**From:** planning  
**Subject:** FW: app3/2017/0160 Stoneyhurst new access road

**From:** Bloomer, David [<mailto:David.Bloomer@lancashire.gov.uk>]  
**Sent:** 13 March 2017 13:23  
**To:** Adrian Dowd  
**Cc:** LHS Customer Service; planning  
**Subject:** FW: app3/2017/0160 Stoneyhurst new access road

The proposal has been the subject of a lengthy correspondence with the applicants consultant and has gone through an iterative process. The proposal put forward in this application has been accepted by the highway authority and as a result I would raise no objection to the proposal on highway grounds but there are a number of issues that will still need to be addressed

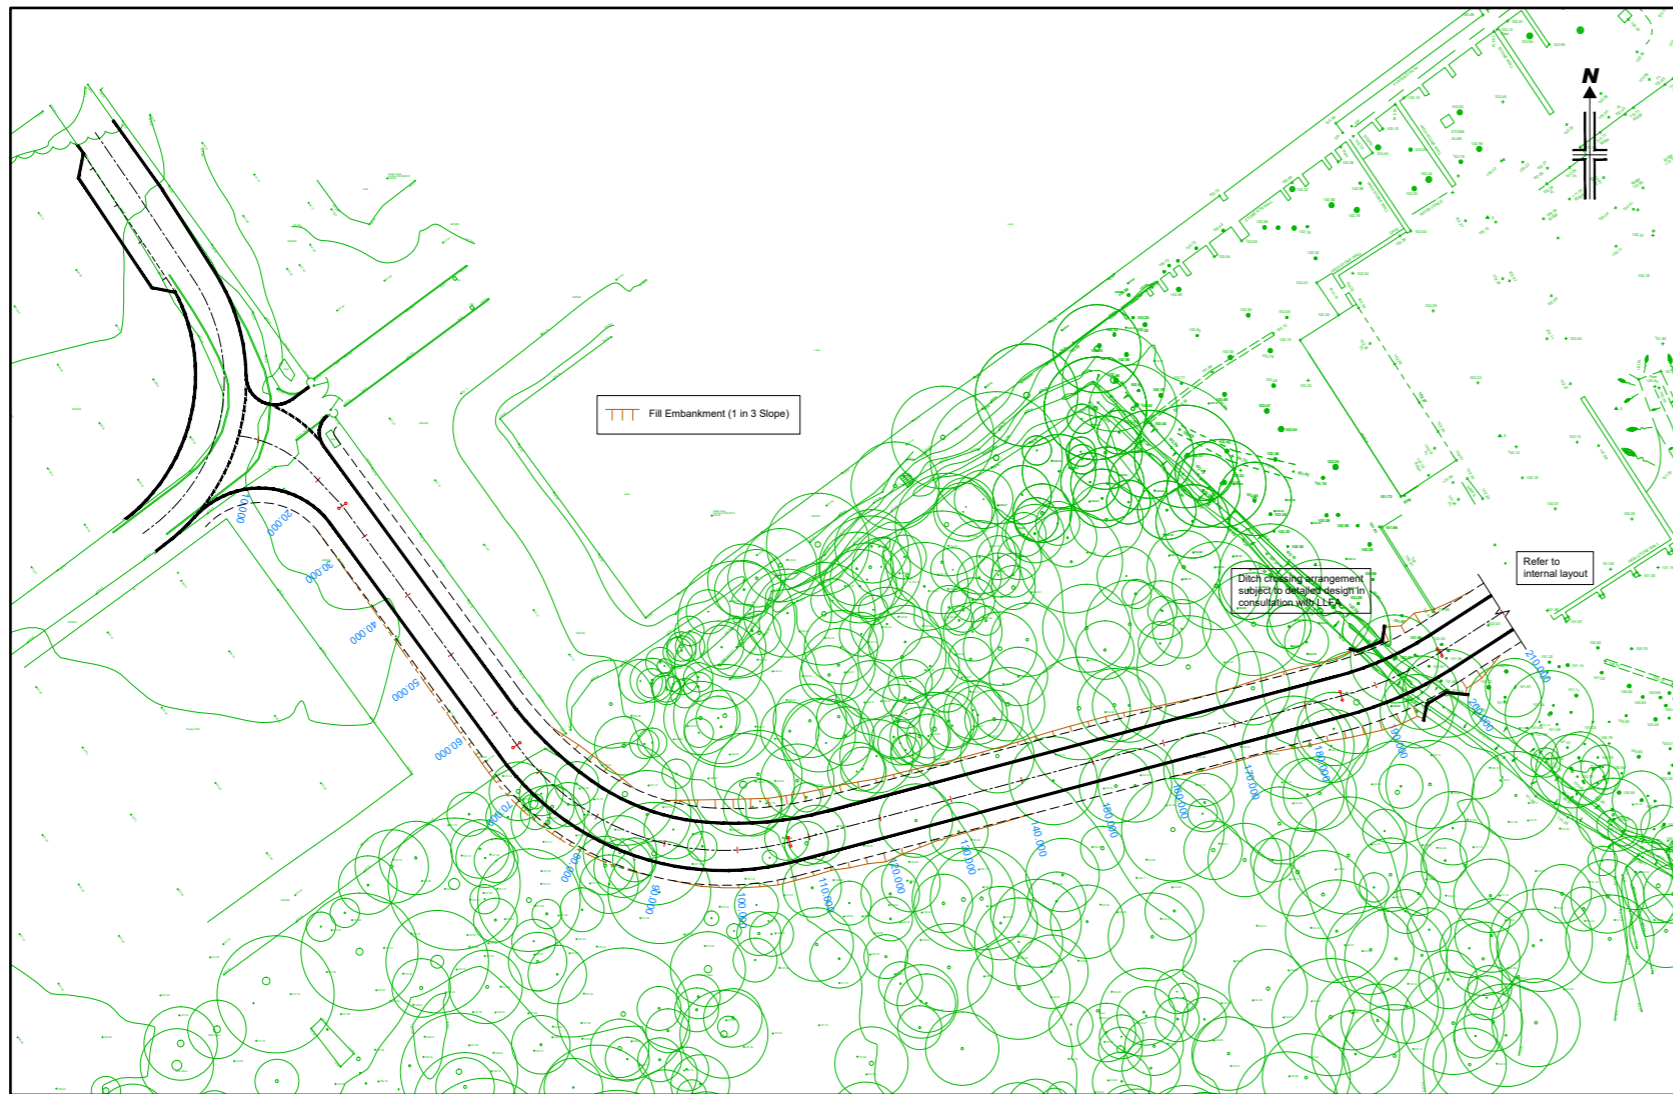
1 During the previous discussions , the applicant proposed the construction of a layby adjacent to the carriageway to the north of the college entrance. This is shown in at least 1 of the submitted plans ( proposed access and long section) but it is not mentioned in the application description. I would need confirmation whether or not this forms part of the application proposals.

2 The applicant would need to provide details of the signing and lining that is to be provided at the site entrance
